MODIFICATION TO SITE 4B COMMERCIAL DEVELOPMENT – SYDNEY OLYMPIC PARK (MP06_0273 MOD 4)

Thank you for forwarding SOPA's correspondence (dated 4 March 2013) regarding the above mentioned application. Please find a response below to each of the matters raised by SOPA.

SITE 4B
SYDNEY OLYMPIC PARK
GROUND FLOOR PLAN

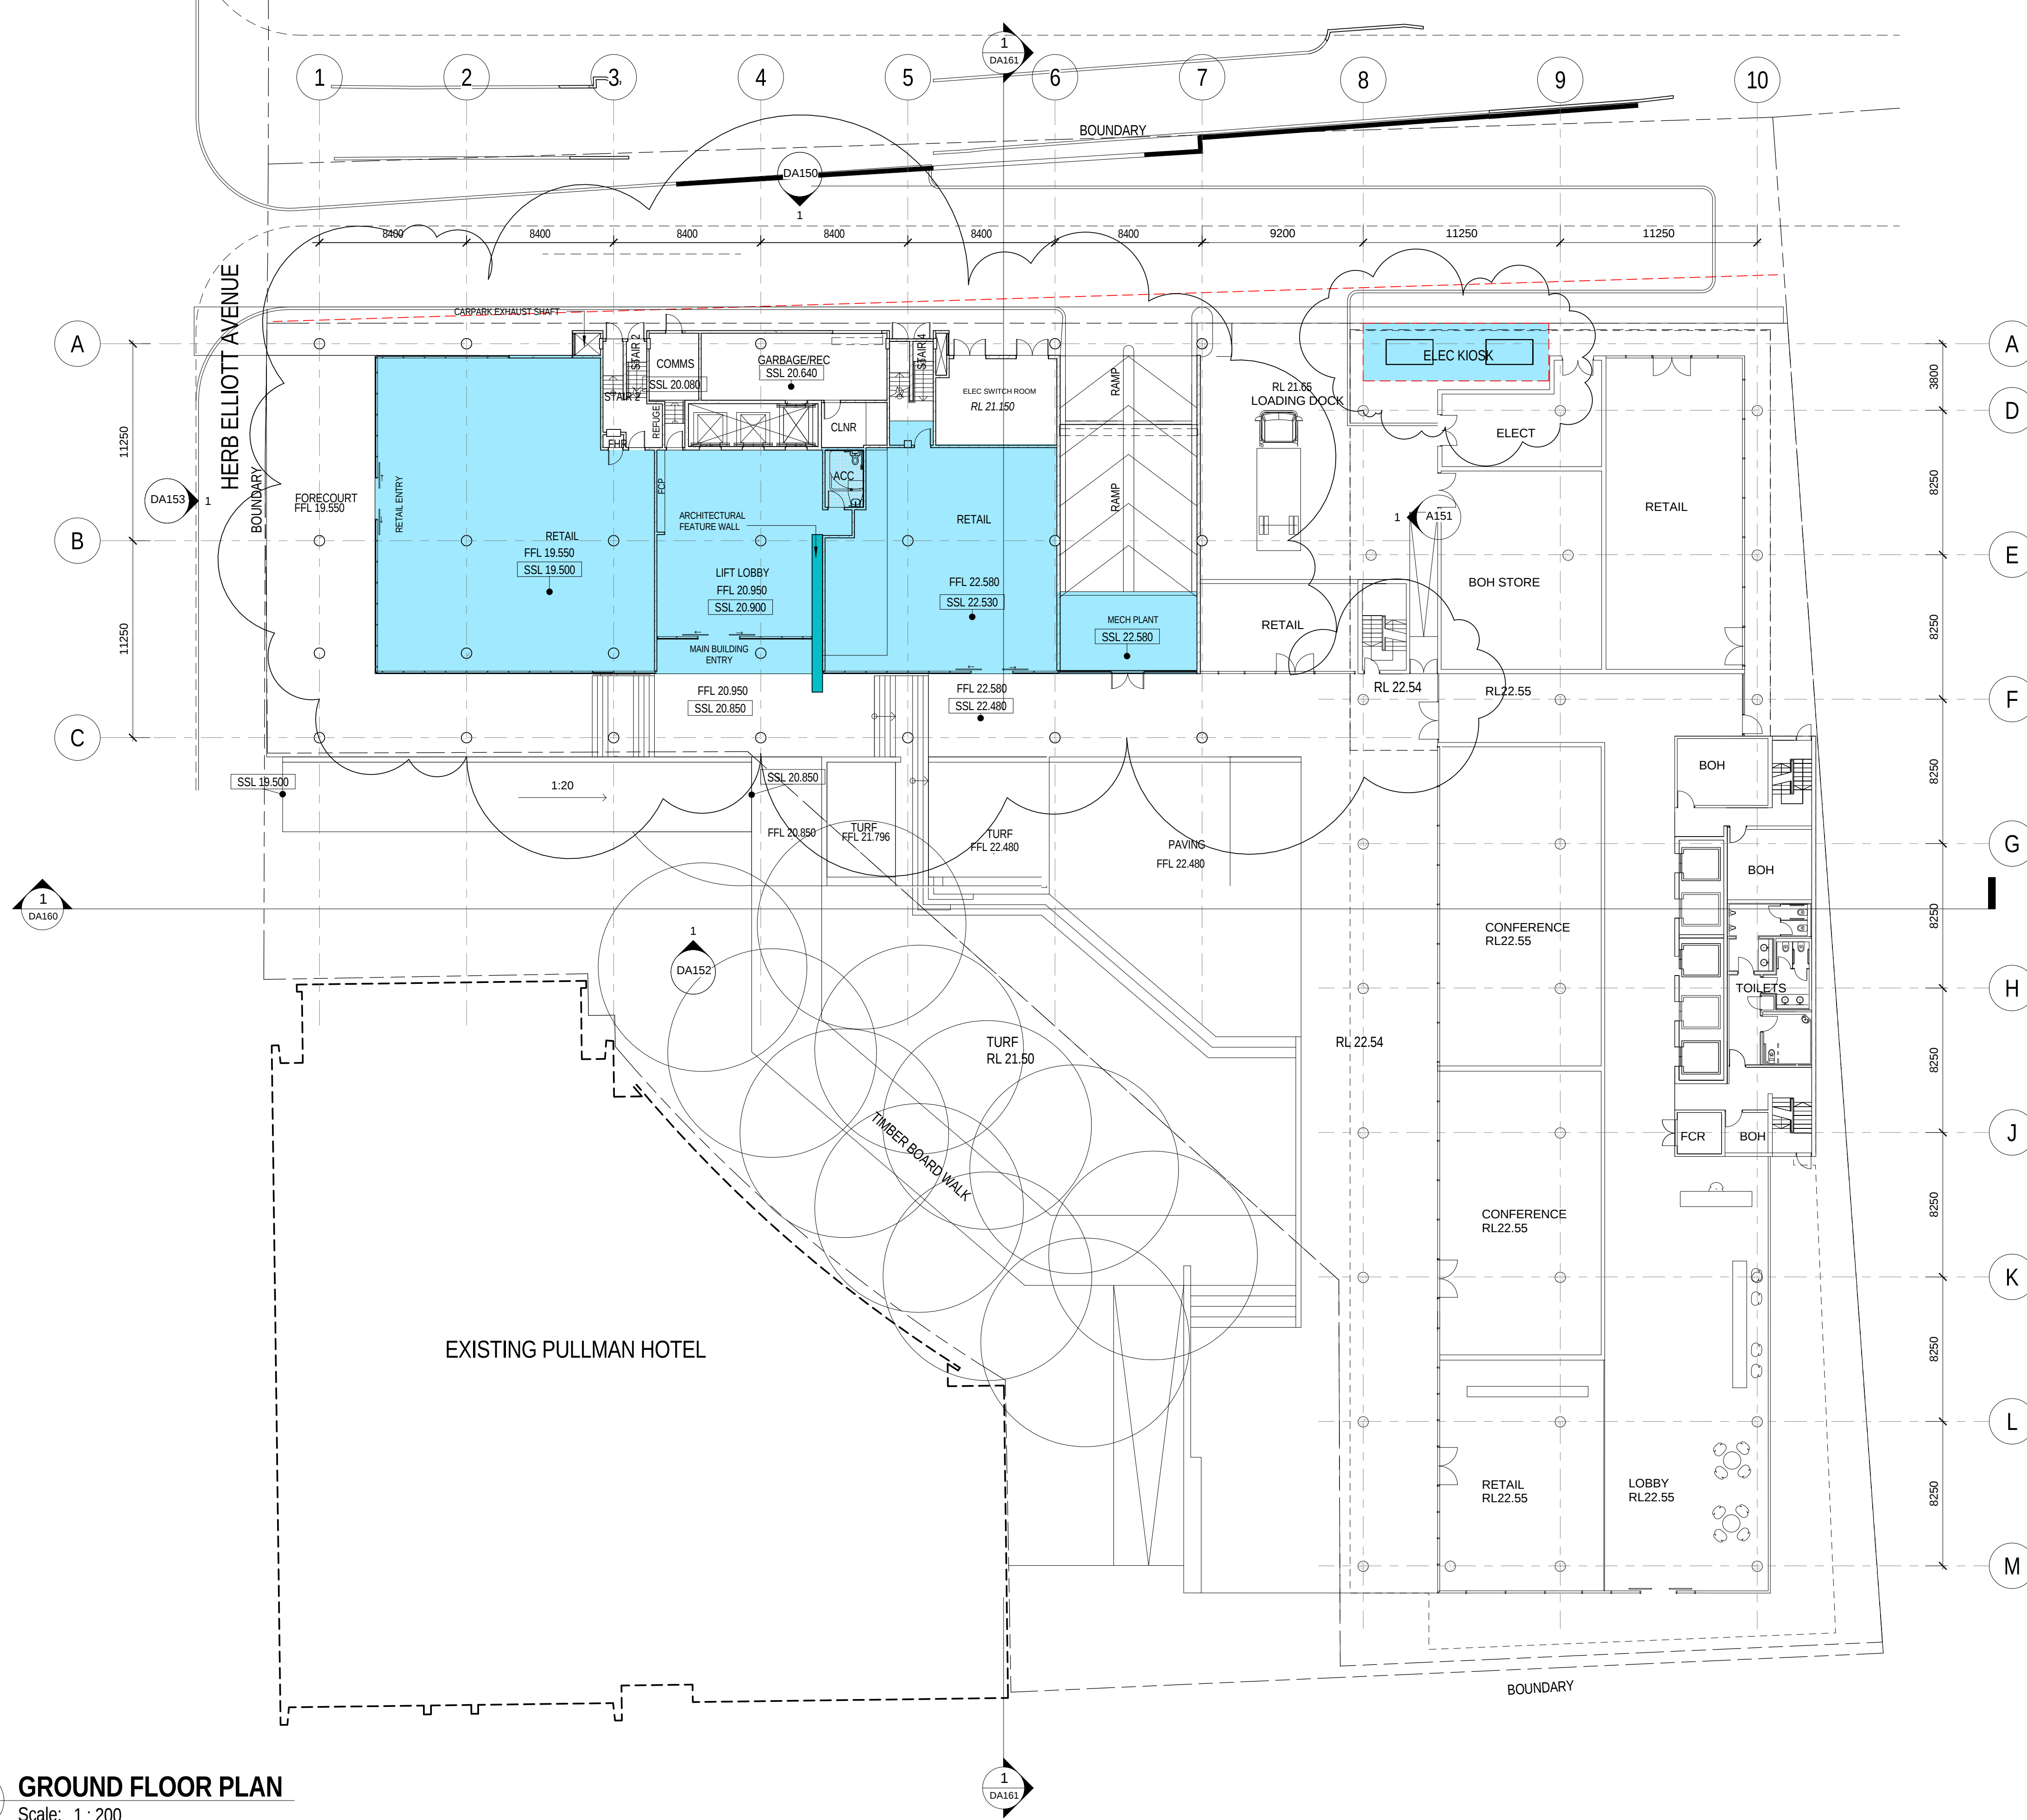
The relocation of the Foyer and reconfiguration of Retail Space has resulted in the smaller of the two Retail Spaces (FFL 22.580) to be non-compliant with the DDA. Accordingly, the Public Domain plan should be revised to ensure compliance with the DDA and SOPA's Accessibility Guidelines.

As outlined in the application, lifting the southernmost retail area to match the height of the external public domain was considered necessary and practical for the following reasons:

- The approved floor level of the southern-most retail tenancy is currently approximately 1.6 metres below the external level of the public domain for the majority of the tenancy frontage. A 3 metre wide entry point therefore becomes the only area with exposure to the public domain at the entry level (FFL20.950). This tenancy would become difficult to lease based on its lack of exposure;
- Lifting the floor level of the southern-most retail tenancy (to FFL22.580) to match the external public domain provides greater opportunities for activating and utilising the public domain, particularly if the tenancy is occupied by a restaurant / cafe operator.

FDC has reviewed the currently approved landscape plan and accept that, although equitable access is available, it does not reflect a direct route given that the development is being constructed in two stages. Furthermore, SOPA has also made ongoing suggestions that the approved boardwalk should be removed given the potential for impact to existing trees.

On this basis, FDC is proposing to modify the Public Domain Plan to delete the approved boardwalk and replace it with a walkway and ramp along the western edge of the northern building structure. Three sketches are attached to illustrate how such access will be maintained for Stage 1, during construction of Stage 2 and at completion of the development.
